AKD/KT
14487
18 May 2016

**SECTION 96(1A) - MODIFICATION APPLICATION TO SSD 6840
ST VINCENT'S PRIVATE HOSPITAL SYDNEY**

On behalf of St Vincent's Private Hospital Sydney (SVPHS), we hereby submit an application pursuant to section 96(1A) of the *Environmental Planning and Assessment Act, 1979* (EP&A Act) to modify Development Consent SSD 6840 relating to the approval of the East Wing building and the SVPHS high-rise building located within the St Vincent's Hospital campus (the site).

Drawing Level Region  
DA-03-002 LXX EW  
EAST WING - WEST ELEVATION

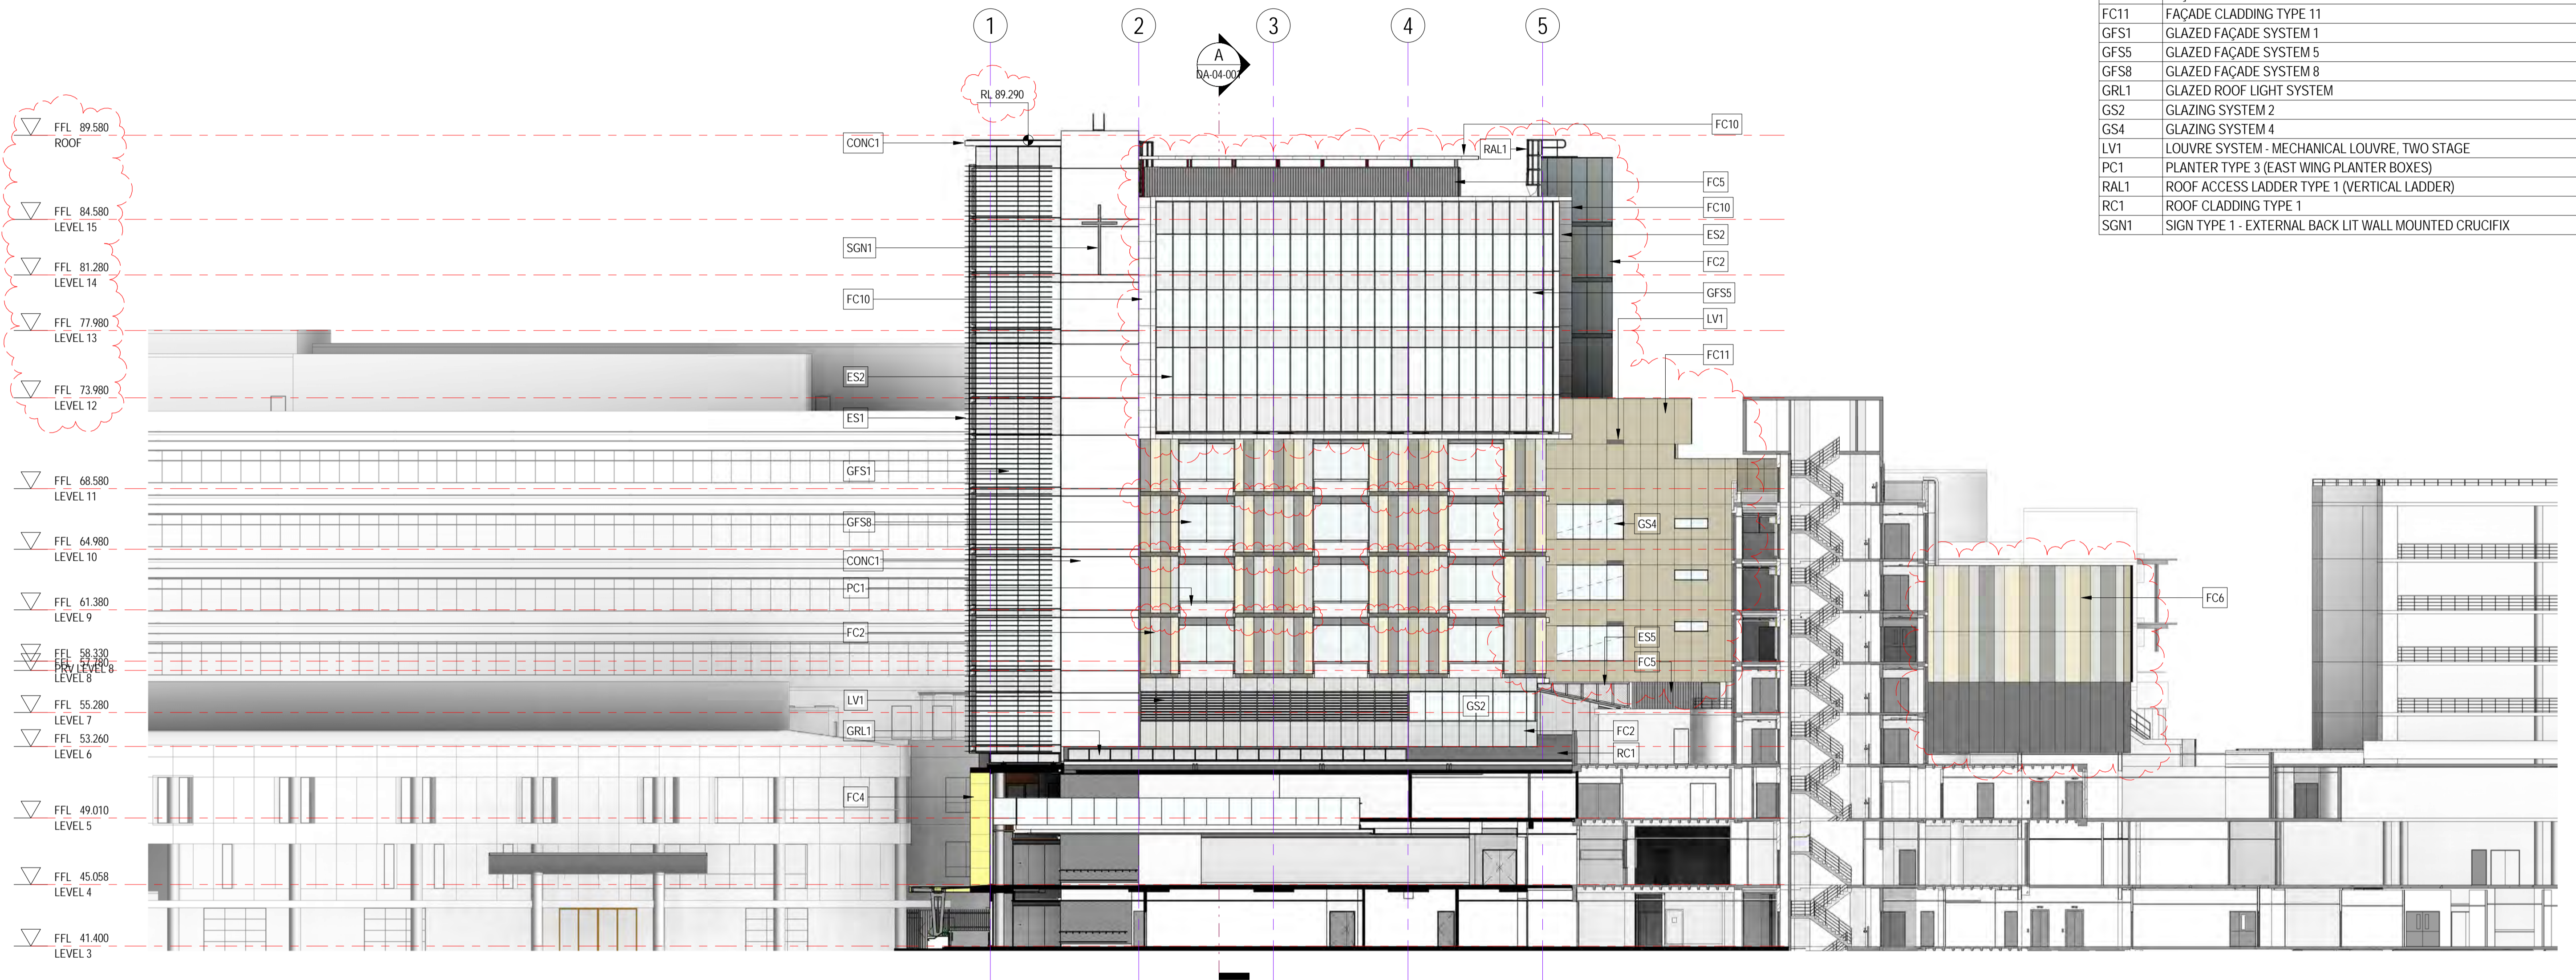
GA Plan – Level 13	<ul style="list-style-type: none"> ▪ Increase in the extent of stair 5. 	DA-01-013	E
GA Plan – Level 14	<ul style="list-style-type: none"> ▪ Increase in the extent of stair 5. 	DA-01-014	E
GA Plan – Level 15	<ul style="list-style-type: none"> ▪ Inclusion of additional meeting room; ▪ Increase in the extent of stair 5; and ▪ Minor amendments to the layout and extent of plant enclosure. 	DA-01-015	F
Victoria Street Elevation	<ul style="list-style-type: none"> ▪ Vertical extensions to ensuites. 	DA-03-001	E
East Wing – West Elevation	<ul style="list-style-type: none"> ▪ Increases and reductions to the floor to floor levels to accommodate the previously approved hydrotherapy pool and inclusion of a split level on Level 12; ▪ Deletion of the high level windows to the ensuites of the high rise building; ▪ Removal of the business identification sign comprising the St Vincent's Hospital logo; ▪ Amendments to the vertical shading design on the East Wing building to increase the extent of the glazing; ▪ Realignment of the spandrel panel to reflect the inclusion of a split level on Level 12; ▪ Reduction in the height of the lift shaft; and ▪ Minor amendments to the materiality of the building. 	DA-03-002	E

The proposed modifications also comprise the removal of the external back-lit building identification sign comprising the St Vincent's Hospital logo from the western (Victoria Street) façade, however seeks to retain the originally proposed cross on this elevation.

Drawing Level Region  
DA-03-003 LXX EW  
EAST WING - NORTH ELEVATION

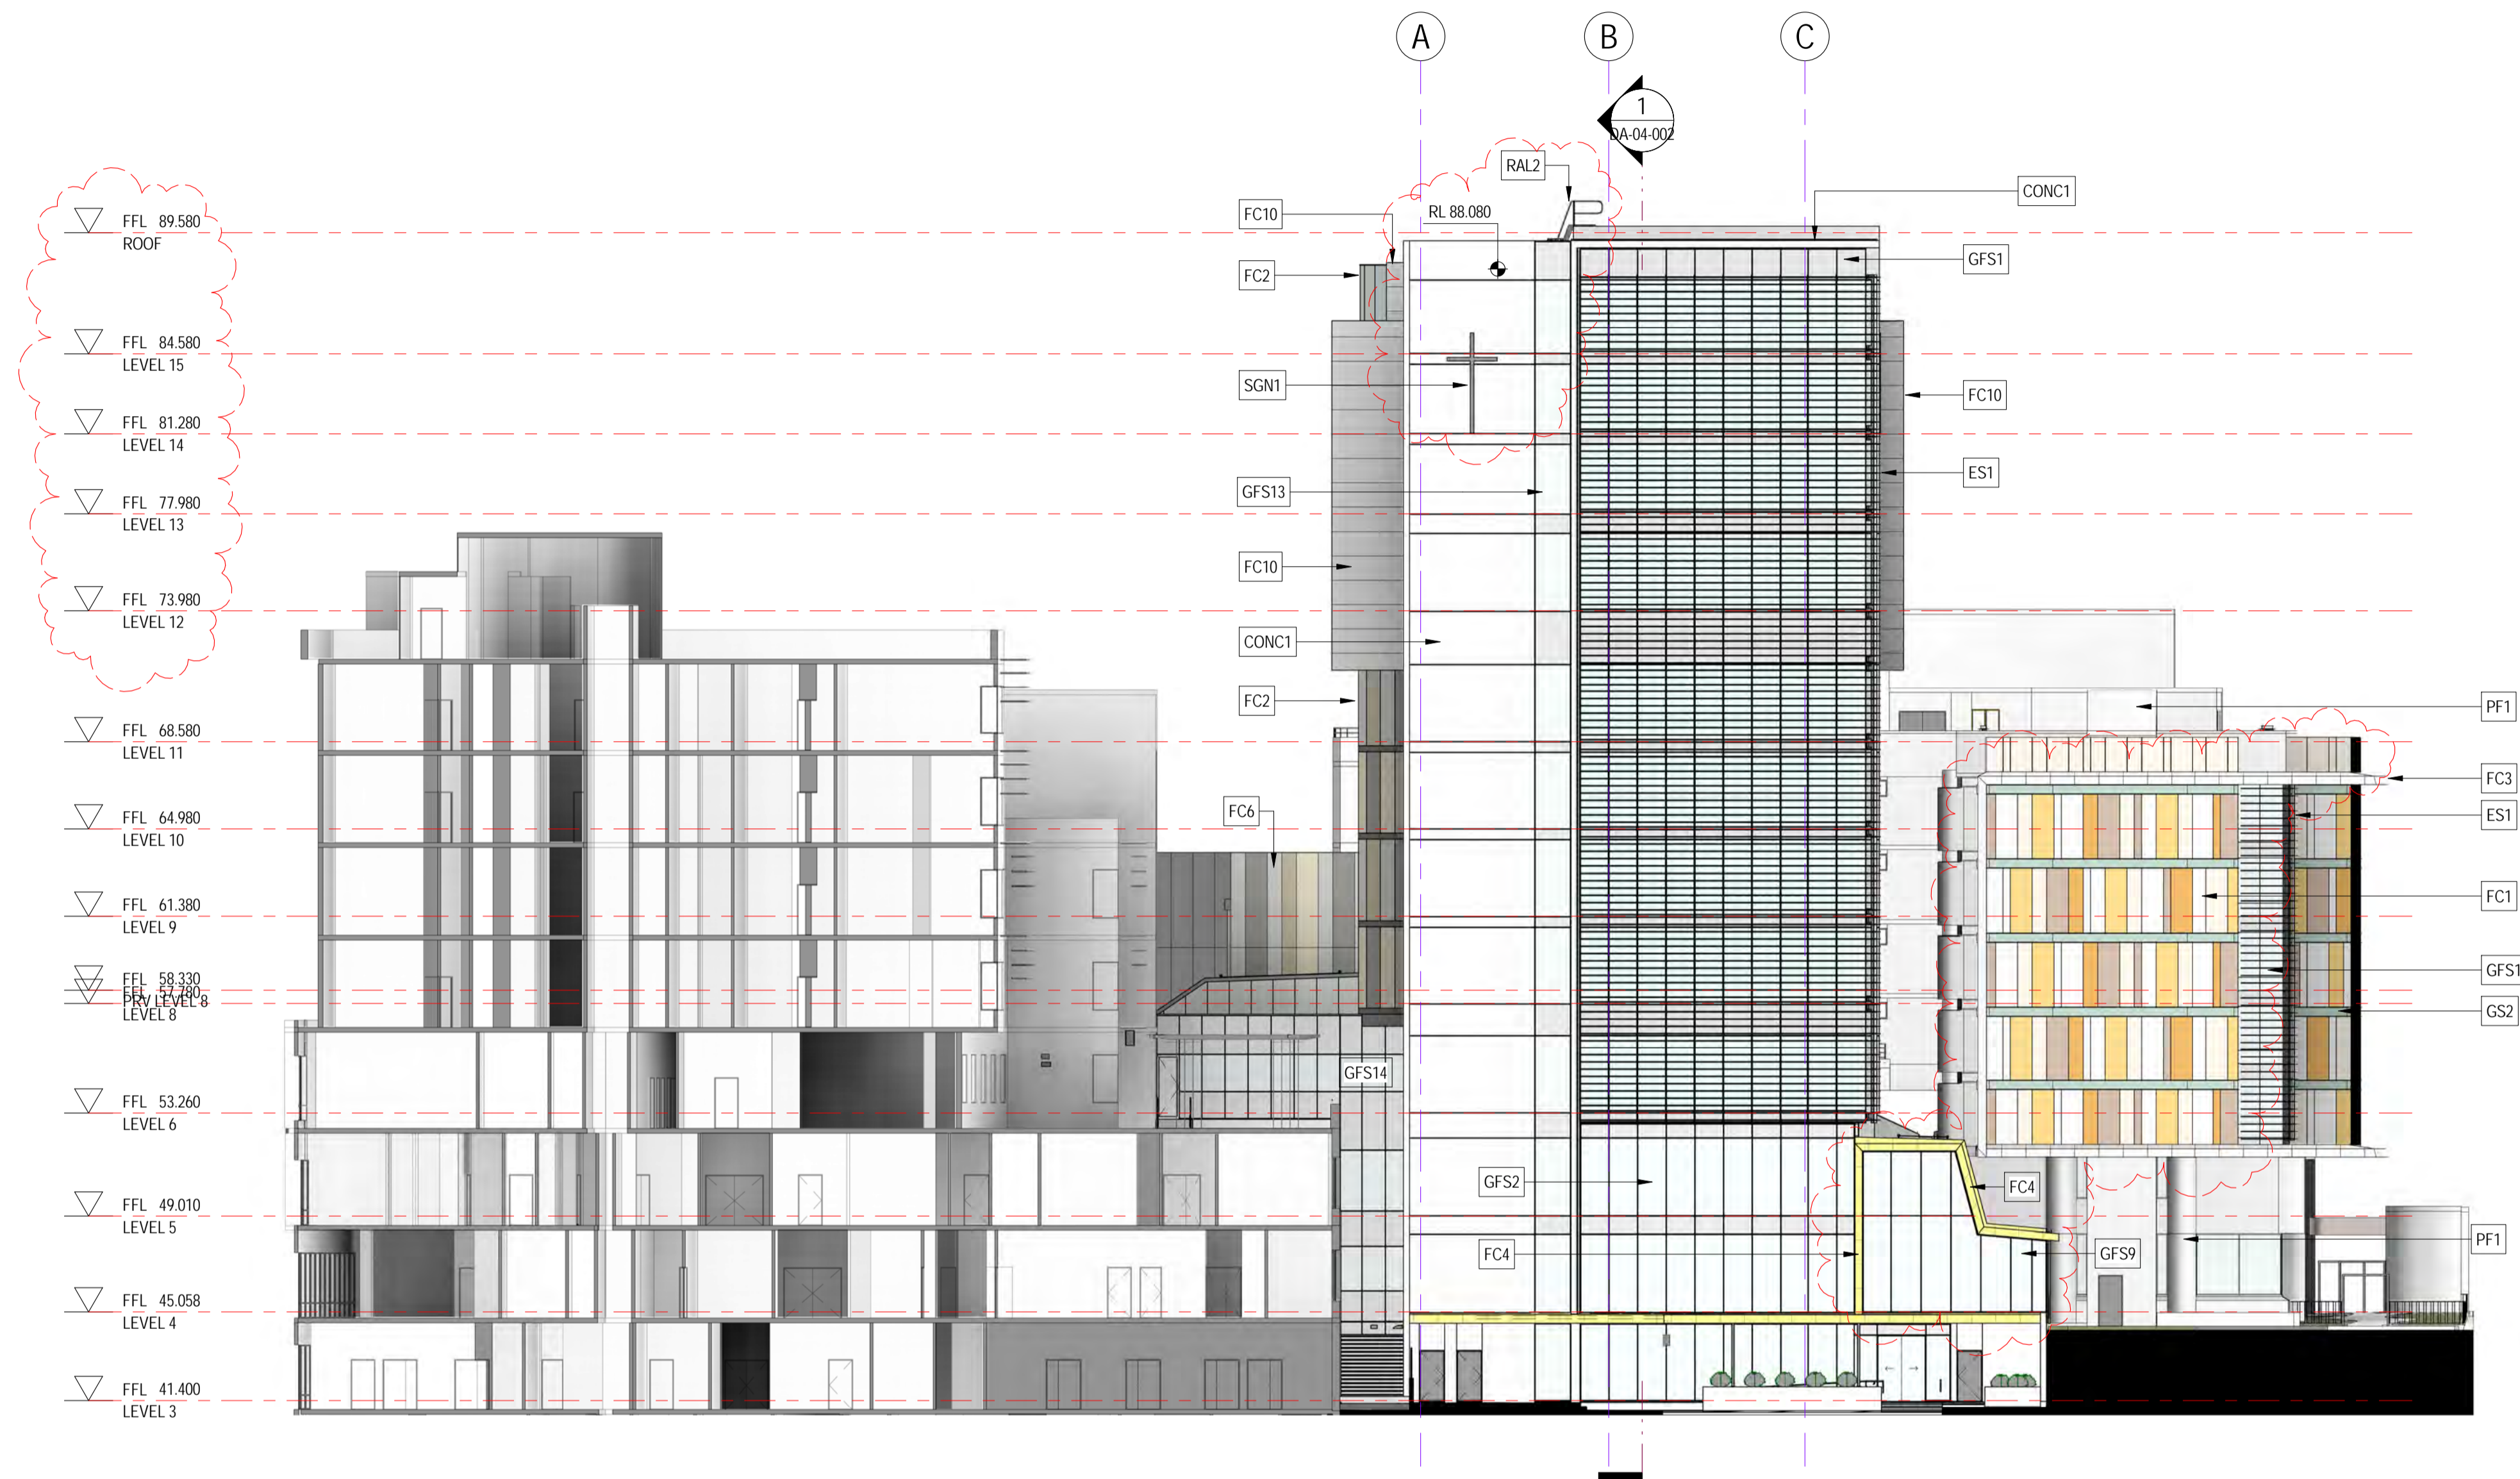
East Wing – North Elevation	<ul style="list-style-type: none"> ▪ Inclusion of additional business identification signage; ▪ Lift shaft height modified; ▪ Amendments to the awning; and ▪ Minor amendments to the materiality of the building. 	DA-03-003	E
East Wing – South Elevation	<ul style="list-style-type: none"> ▪ Amendments to the vertical shading design on the East Wing building to increase the extent of the glazing; ▪ Realignment of the spandrel panel to reflect the inclusion of a split level on Level 12; and ▪ Increase in the extent of stair 5. 	DA-03-004	F
East Wing – East Elevation	<ul style="list-style-type: none"> ▪ Increases and reductions to the floor to floor levels to accommodate the previously approved hydrotherapy pool and split level; ▪ Deletion of the high level windows to the East Wing building; and ▪ Realignment of the spandrel panel to reflect the inclusion of a split level on Level 12. 	DA-03-005	E

The proposed modifications include the installation of a building identification sign on the northern elevation of the East Wing (refer to **Figure 1**). The signage is proposed to comprise an external, back-lit cross with a height of 4.1m and a width of 2.1m. The proposed sign projects 300mm from the building façade.

Drawing Level Region  
DA-03-004 LXX EW  
EAST WING - SOUTH ELEVATION

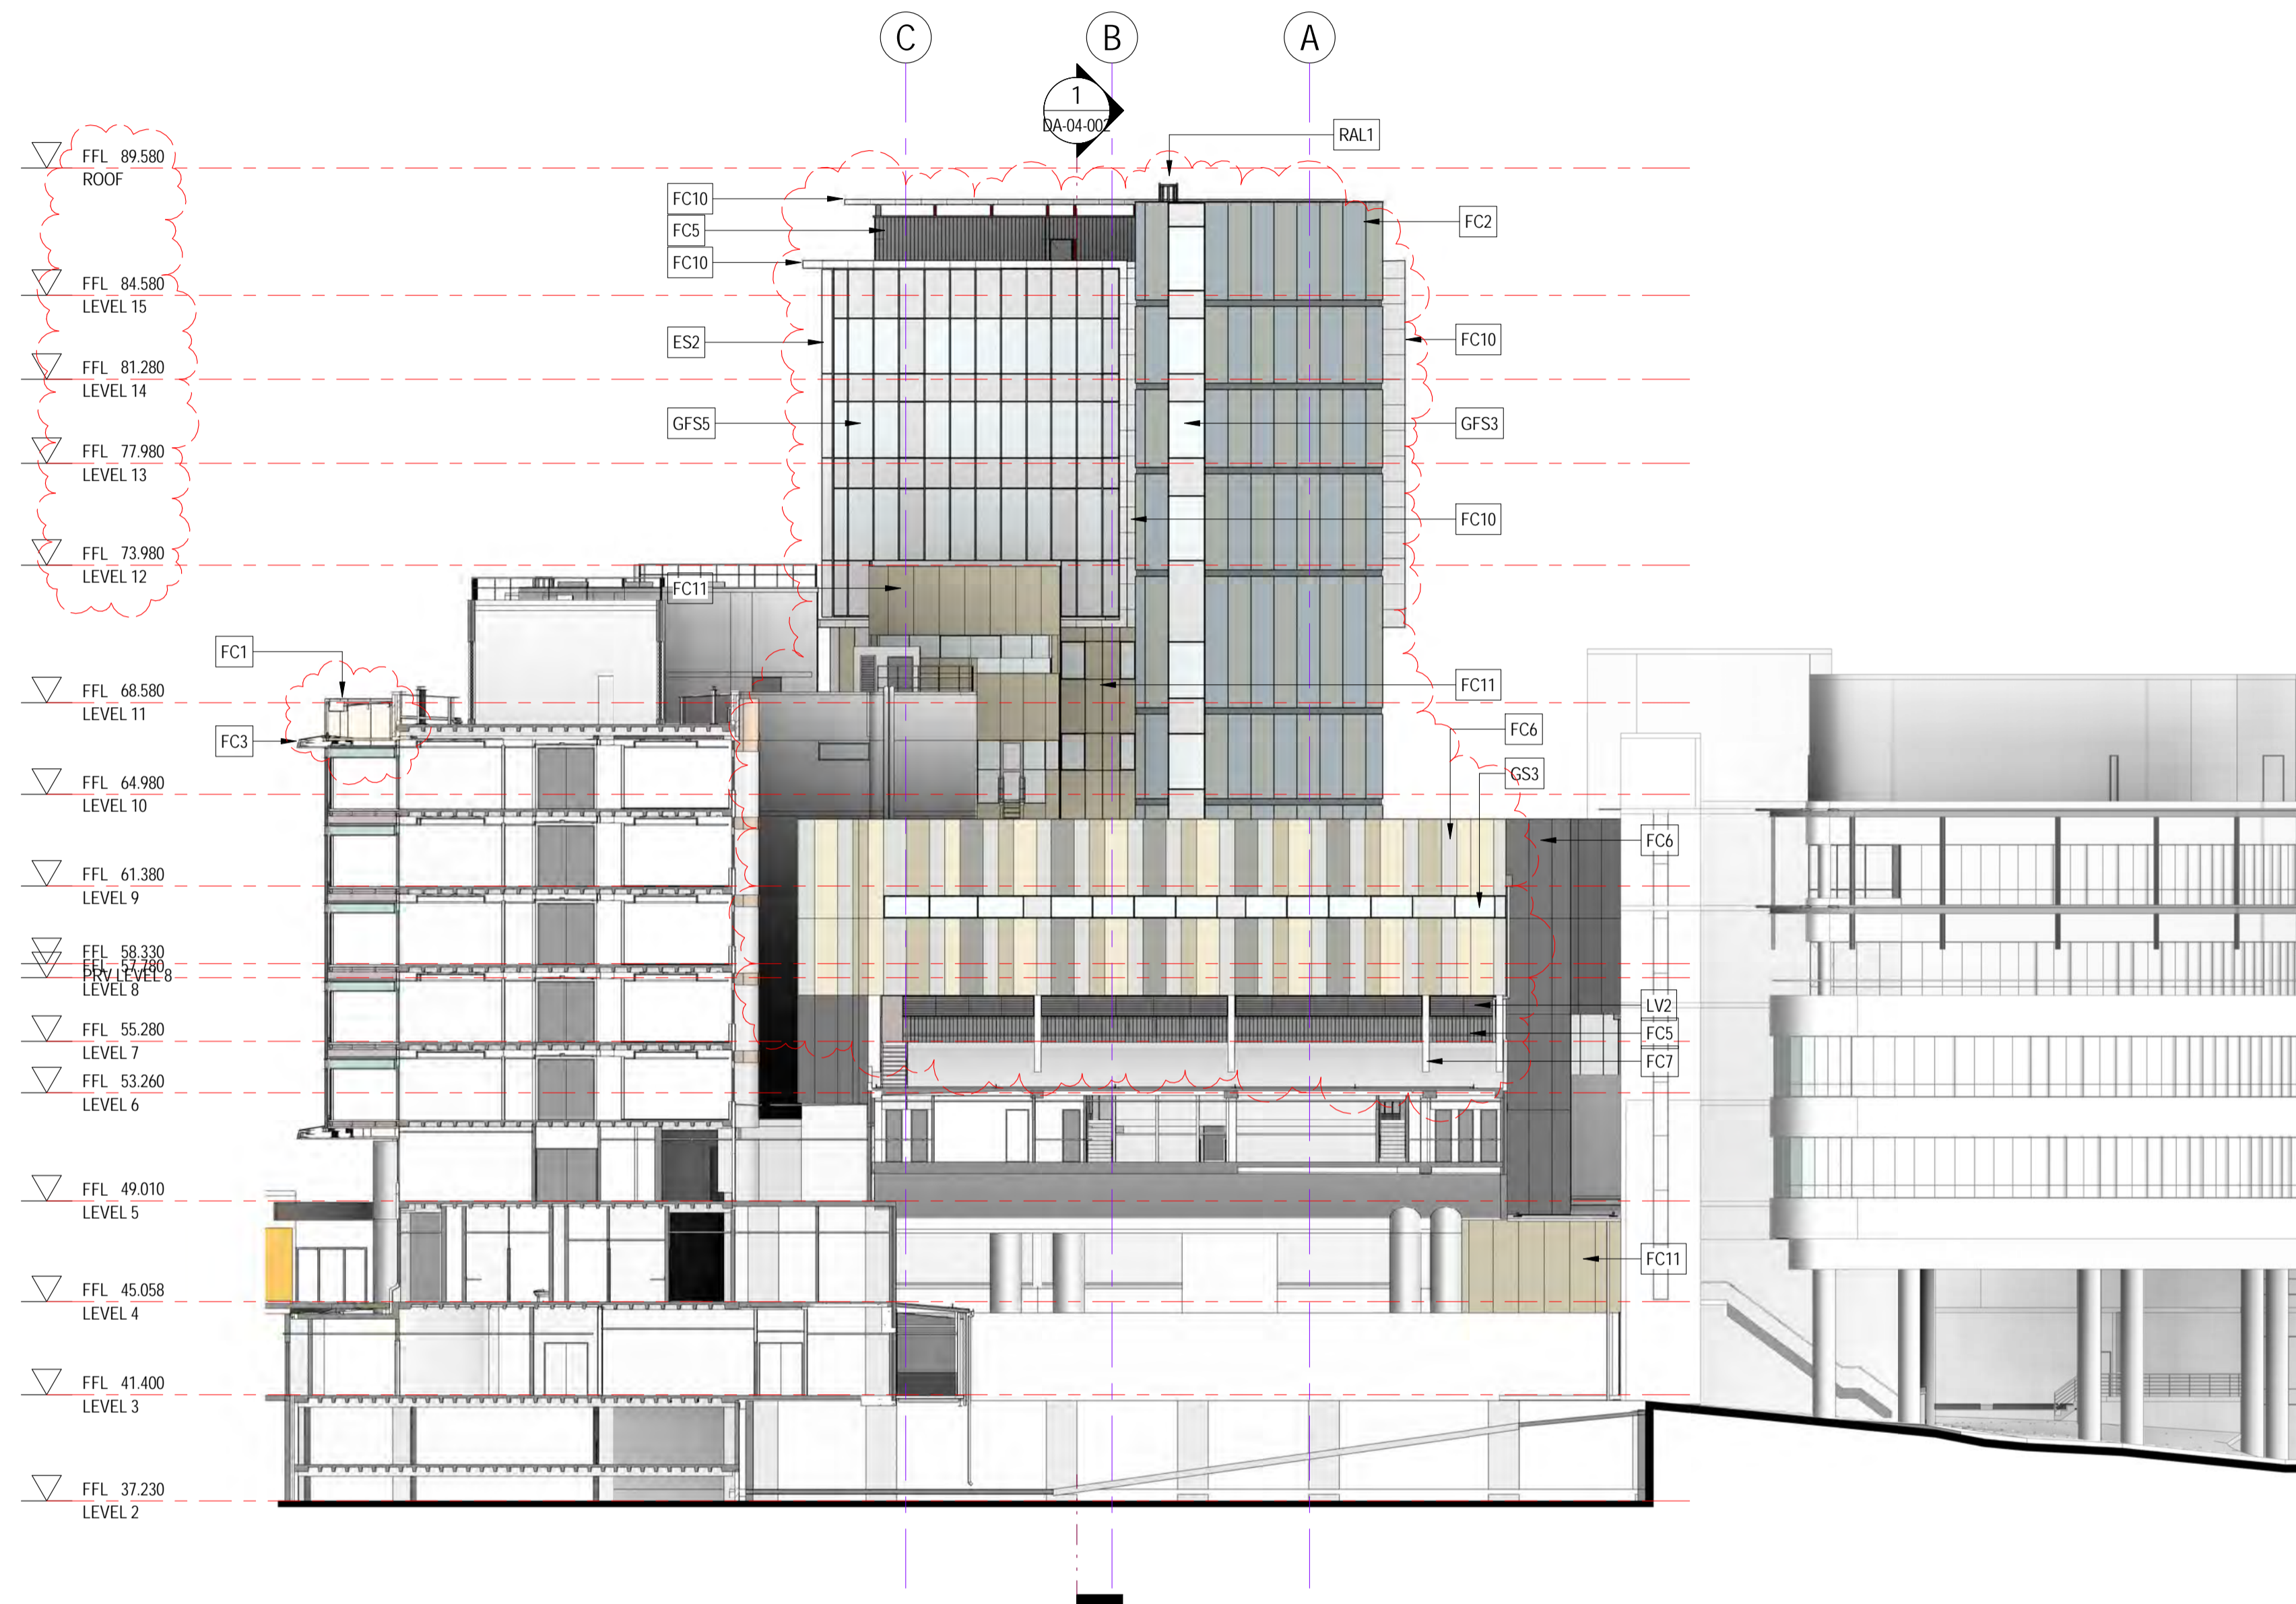
The introduction of a split level on Level 12 of the East Wing building necessitates updates to the external façade comprising an increase to the extent of the spandrel panels on the east, south and west elevations. Further, the vertical sun shading devices on the East Wing building have been revised to allow for improved access to views.
